**Fire Marshal Division**

**Re: Levine Hall Alterations  
260 Leslie Campbell Ave.  
Lillington, NC 27546**

**Application Number BCOM1811-0003**

Fire Sprinkler Plan	
CONTRACT NO.	CC-6070
APPROVAL	Harnett County
DRAWN BY	DLN
SCALE	1/8" = 1'-0"
DATE	12/31/2018
REVISED	
PLOTTED	FP1

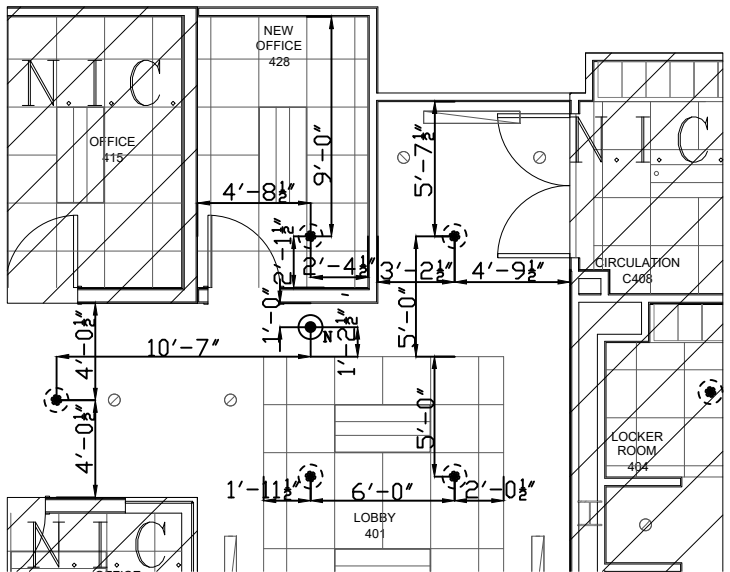
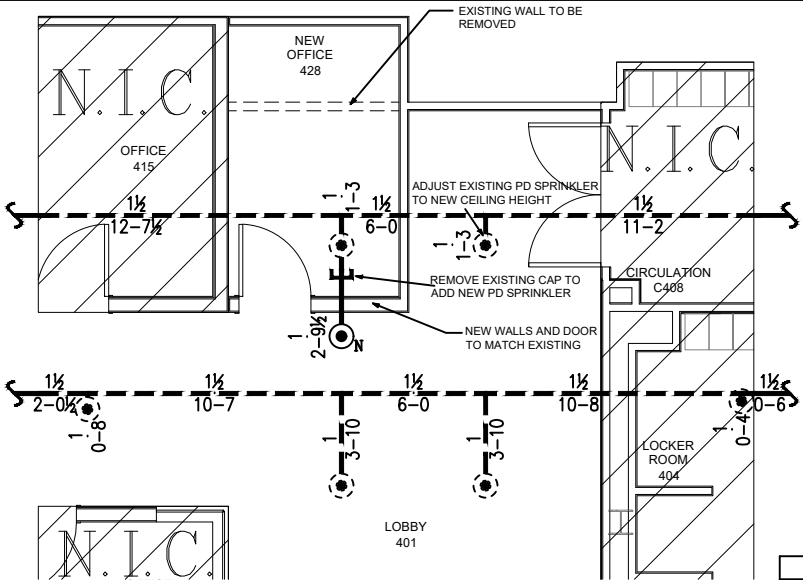
- **901.2.1 State of Compliance.**
  - Before requesting final approval of the installation, where required by the fire code official, the installing contactor shall furnish a written statement to the fire code official that the subject fire protection system has been installed in accordance with the manufacture's specifications and the appropriate installation standard. Any deviations from the design standards shall be noted and copies of the approvals for such deviations shall be attached to the written statement.
  - All work shall be performed in accordance with NFPA 13 and the NCSFC.

- **Penetrations**
  - All penetrations in fire rated construction must be UL listed and inspected.

PROJECT NO.	514.6915.00
ISSUE DATE	10/19/18
SCALE	1/4" = 1'-0"
SKETCH DRAWING	A-2

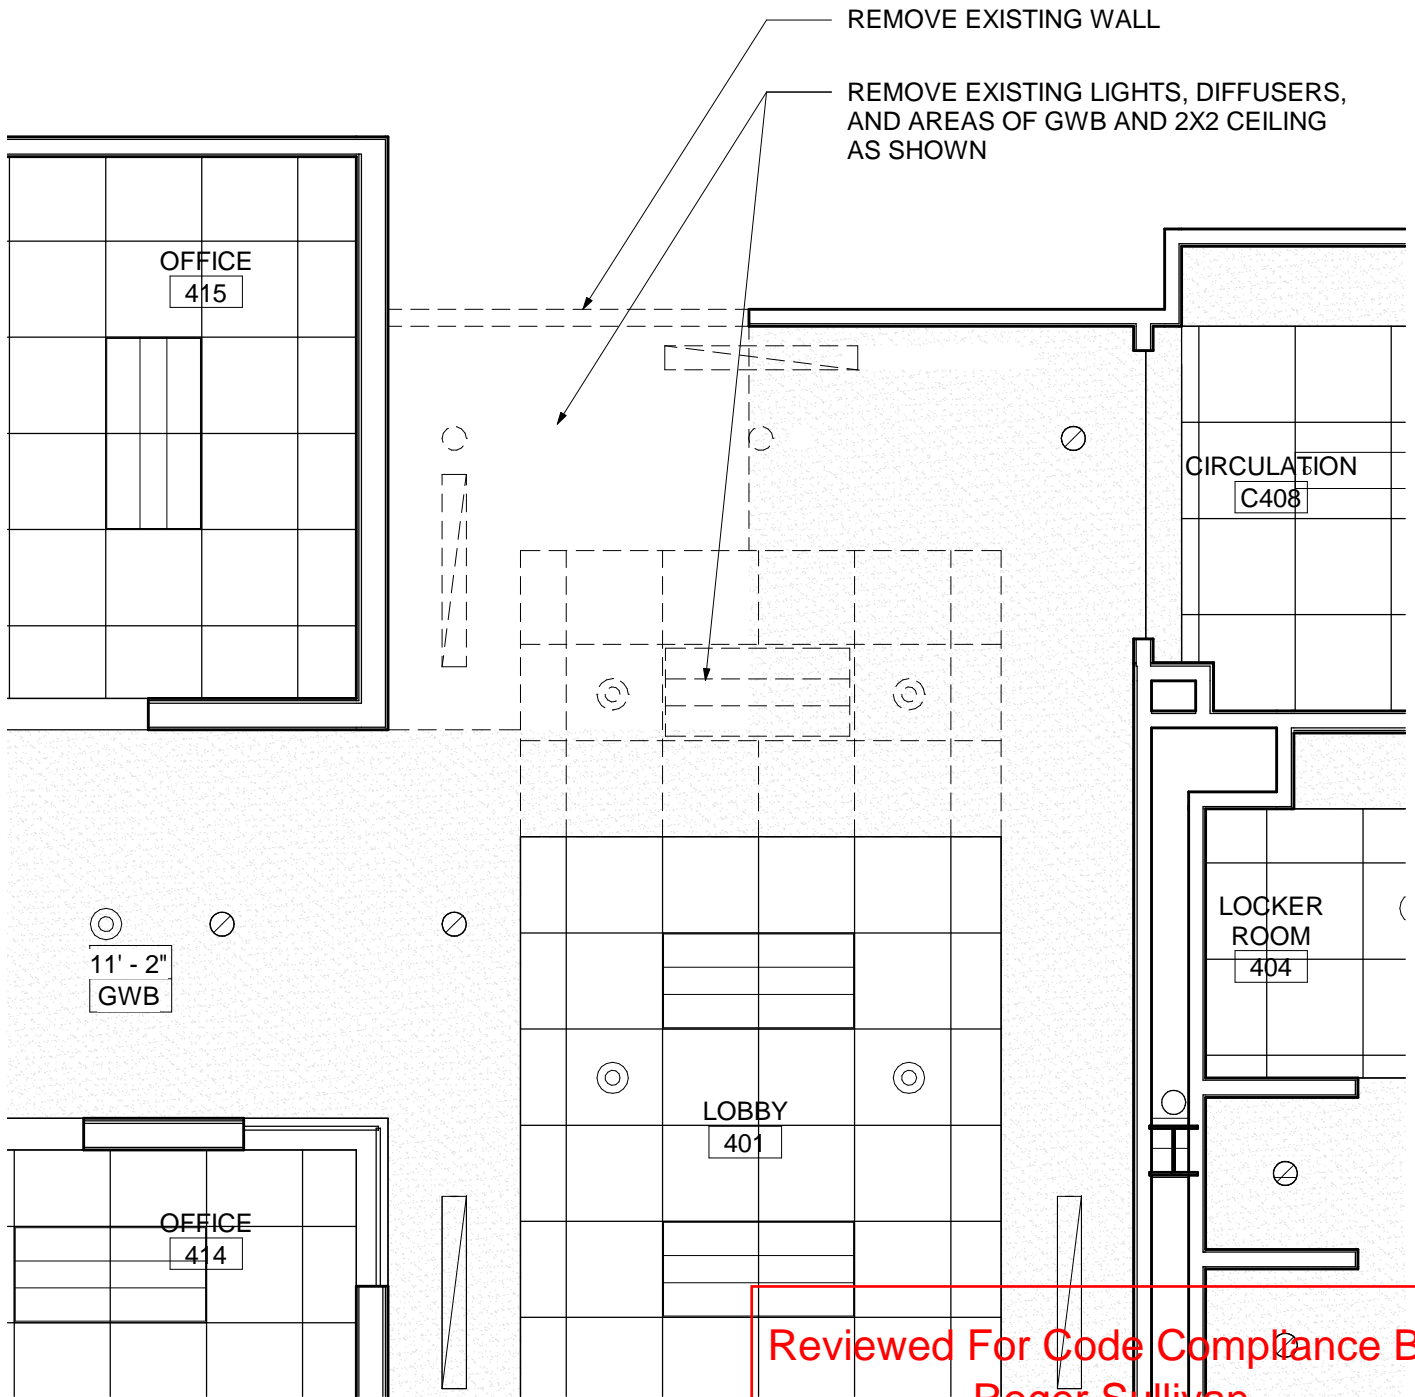
- **Smoke Detectors**
  - A smoke detector shall be located in each office space. This may occur by relocating or adding additional detectors as required for coverage.
  - The detectors shall be compatible with existing detectors and alarm system.
  - All equipment and work shall be conducted per NFPA 72.
  - **A certification of completion, from the alarm company and an acceptance test shall be provide at final inspection.**
